**From:** Mundy, Ben - Oxfordshire County Council <Ben.Mundy@Oxfordshire.gov.uk>  
**Sent:** 01 November 2022 15:36  
**To:** DC Support; Rebekah Morgan  
**Cc:** Transport CDC Minor  
**Subject:** 22/03049/OUT Land West Of Oxford Close And North Of Corner Farm, Station Road, Kirtlington

**Planning Application:** 22/03049/OUT

**Location:** Land West Of Oxford Close And North Of Corner Farm, Station Road, Kirtlington

**Description:** Provision of eight single-storey and two-storey detached and semi-detached dwellings with access, parking and amenity space

Parameter Plan - Access and Movement | Lince Lane, Kirlington

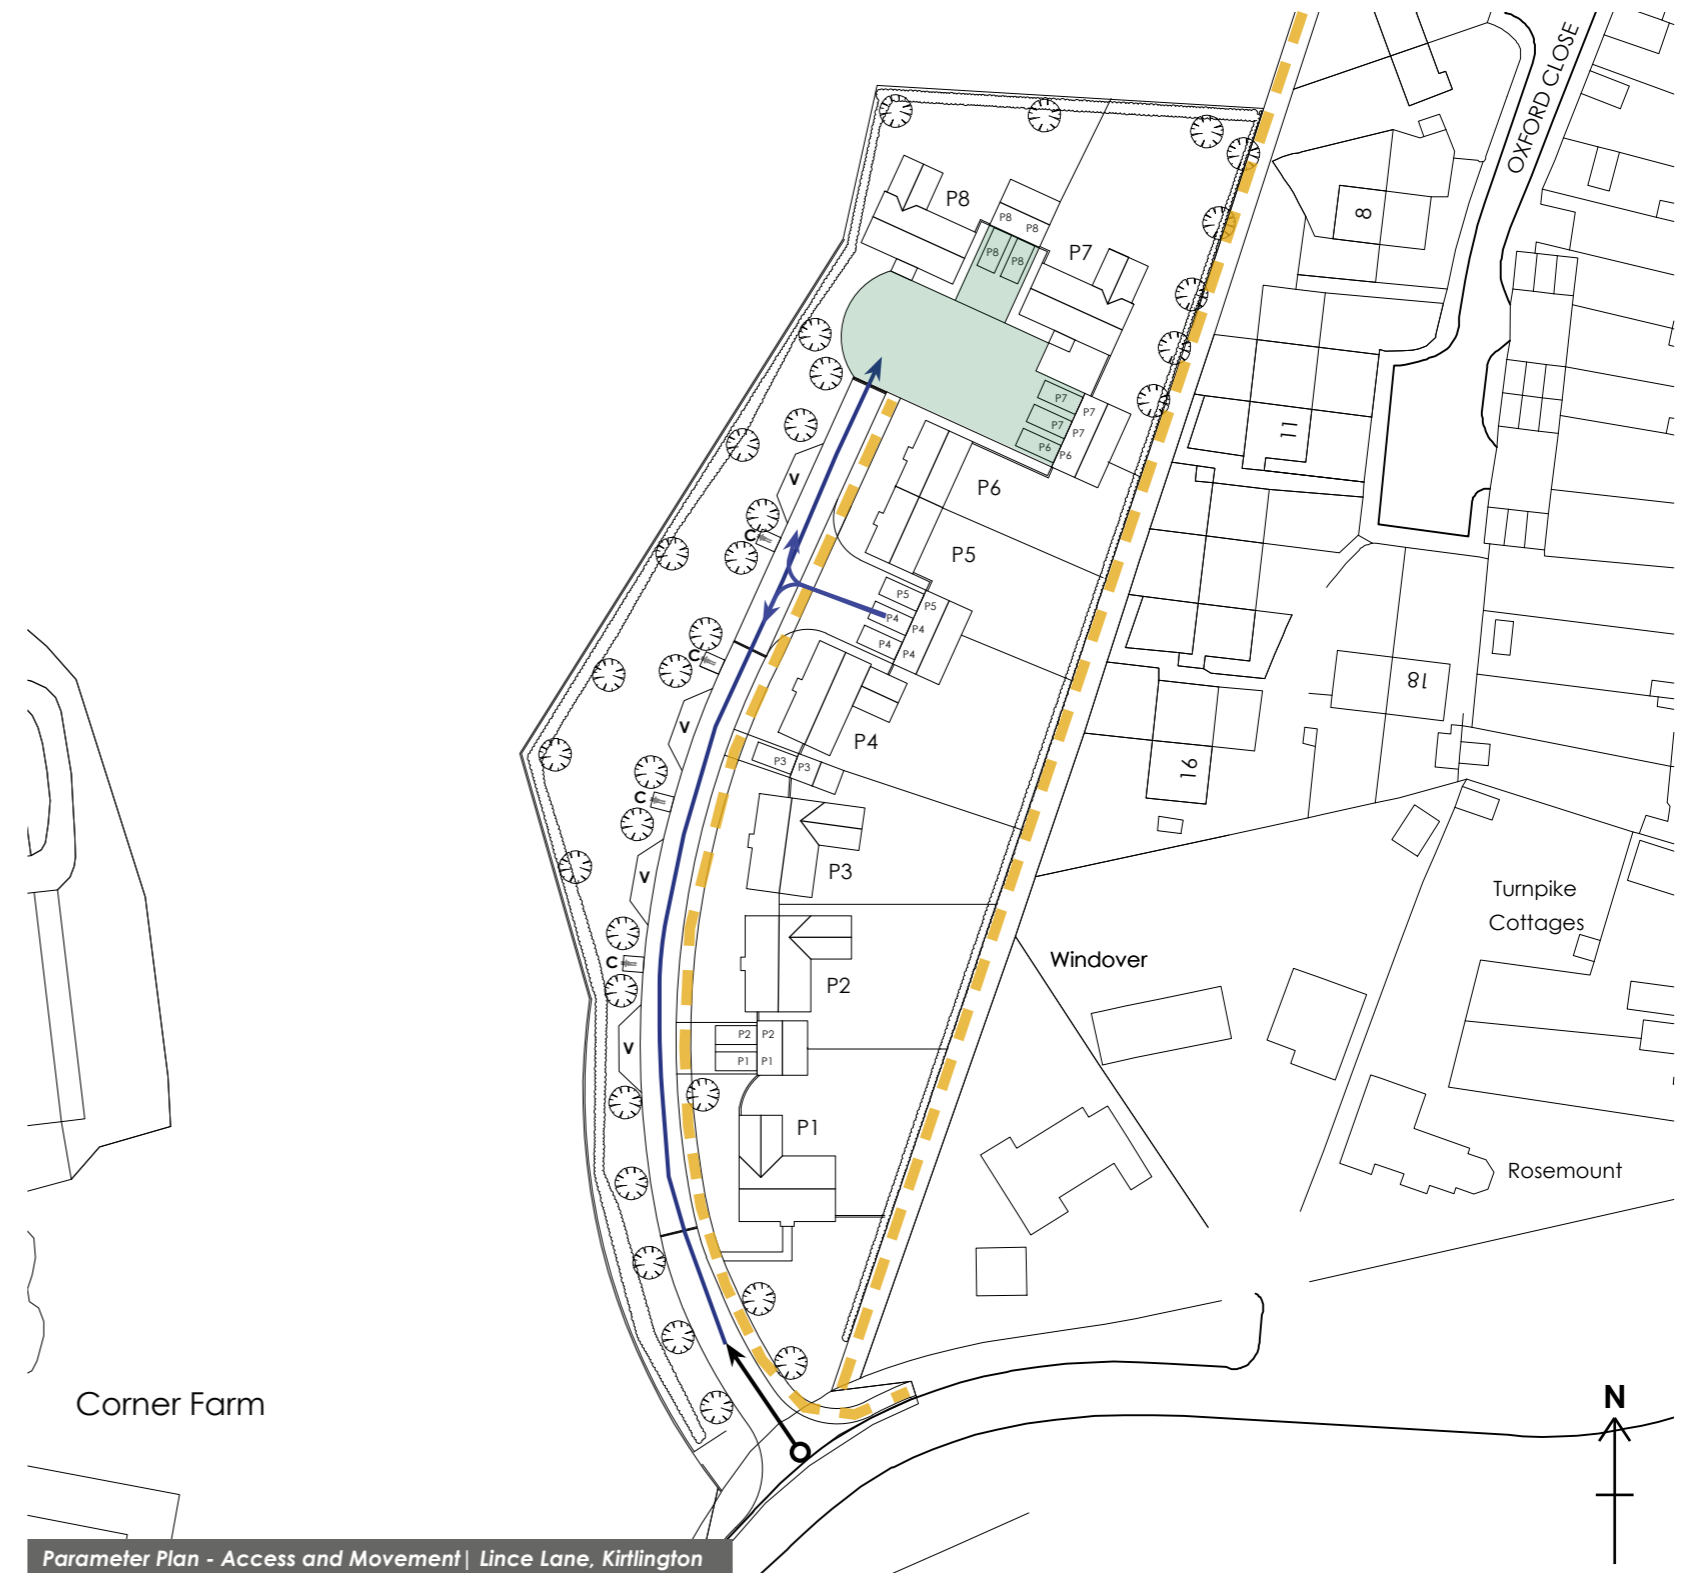
The current proposals for the site, do not show a pedestrian link from the site to the existing footway network within Kirtlington Village. This means that there is no safe walking route for pedestrians looking to access the village amenities. This presents the obvious safety issue, but also inadequate sustainable travel facilities have the potential to create a car dependent development as per LTN 1/20, something OCC are strongly opposed to.

All sections of road that measure over 70m in length must have traffic calming measures in place to ensure that vehicles speeds remain under 20mph.

Given the positioning of the access to this site, it is not going to be possible for refuse vehicles to stop on the A4095. Therefore a swept path analysis for a 11.6m refuse vehicle should be carried out, to prove that it can manoeuvre around the site safely. The vehicle must not overhang any of the footways and should also be tracked passing a parked car.

SCALE: 1:500	DATE: 02.09.22	DRAWN: TW	CHECKED: DF	APPROVED: DF
JOB NO: 2207-015	DRAWING NO: VS01	REVISION: A

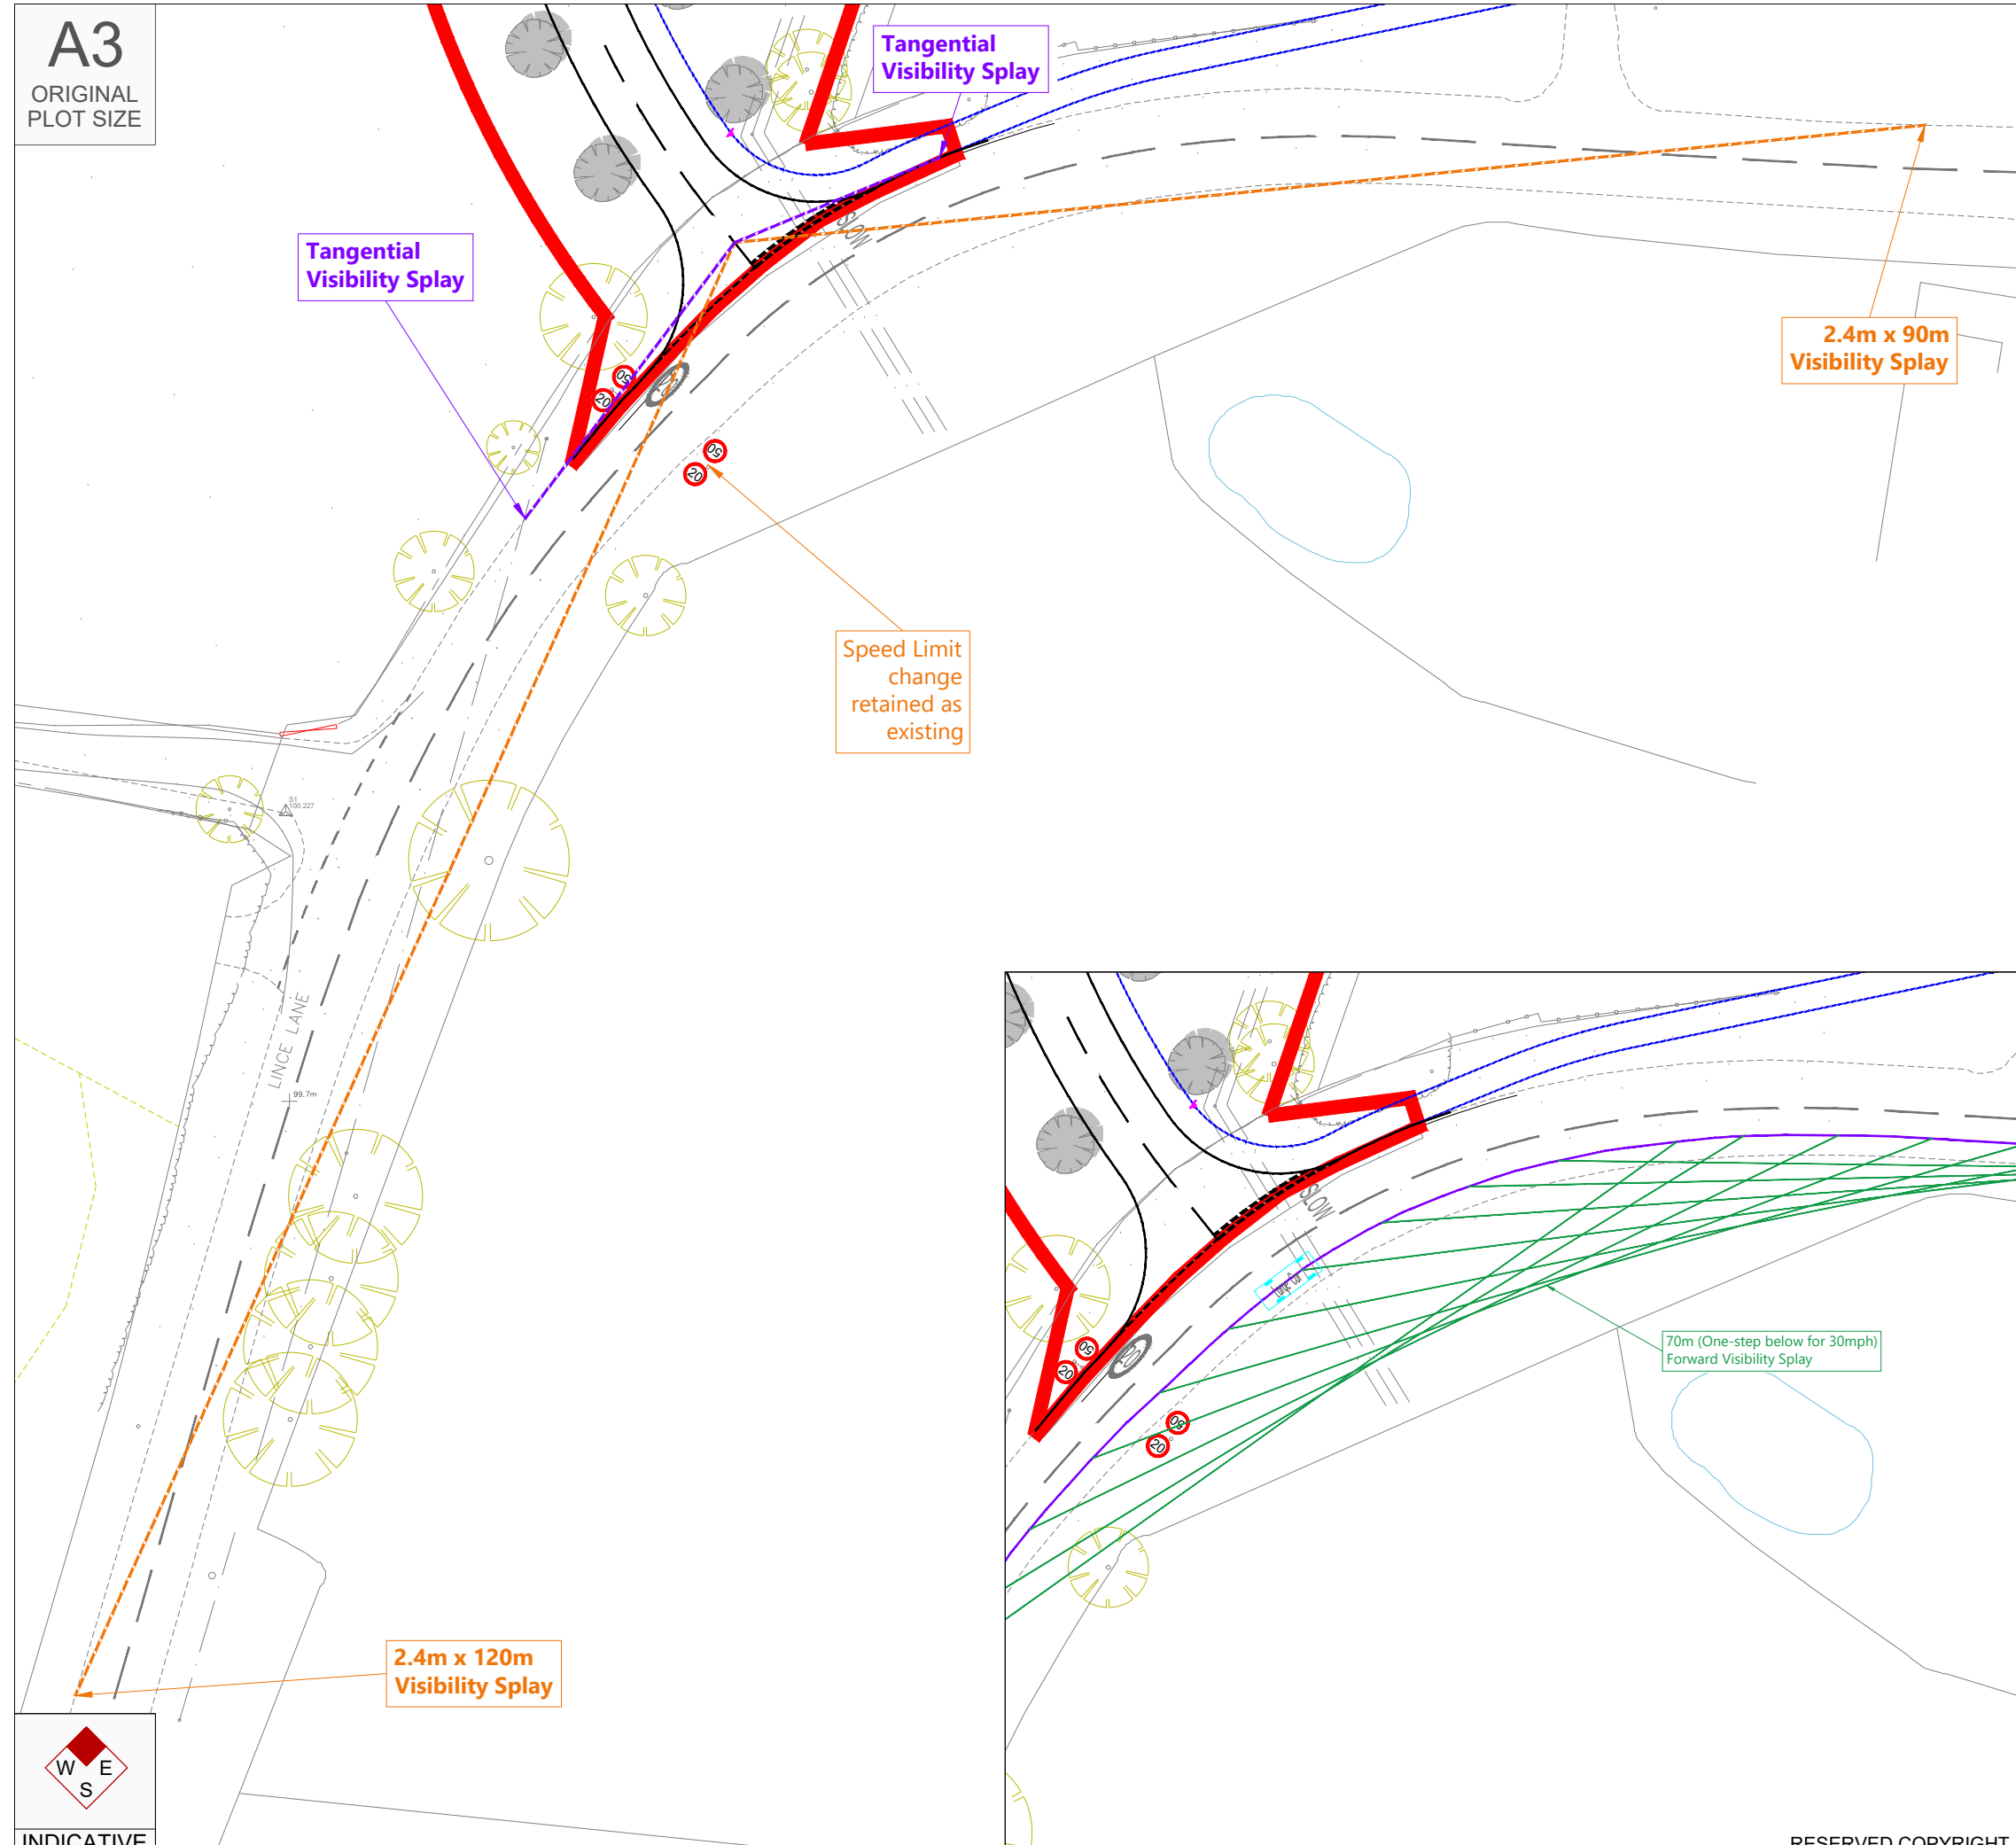
The proposed access is positioned on a corner that features a prominent crest, limiting visibility. The village has recently changed to a 20mph limit meaning that in normal circumstances, it would only require a 2.4m x 22m visibility splay. However, the access is in close proximity to a speed limit change (50 to 20), meaning that it is likely that speeds could be higher than 20mph as vehicles do not slowdown in time. I would therefore recommend that the applicant is to submit a speed survey, in order to work out the 85<sup>th</sup> percentile of speed, using this to determine what the required splay should be, this should be conducted over a minimum of 1 week. The splays are then to be submitted to the Local Planning Authority for approval.
